Mellor Parish Council

25th July 2011

Planning Application

3/2011/0432 3 Arley Rise, Mellor - *Proposed rear and side extension. Raise roof by 1.5m to provide rooms in the roof space.*

PROPOSED EAST ELEVATION

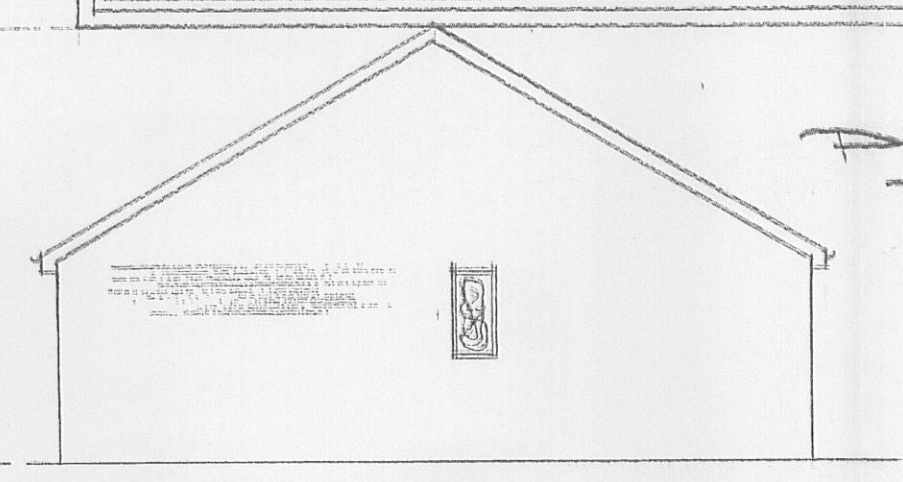
1. Overlarge development.
2. Out of proportion to neighbouring properties.
3. Substantial detrimental impact upon neighbouring properties. The eastern elevation extends to the boundary fence impacting upon no. 1 Arley Rise.
4. Privacy & light concerns were expressed for the neighbours.
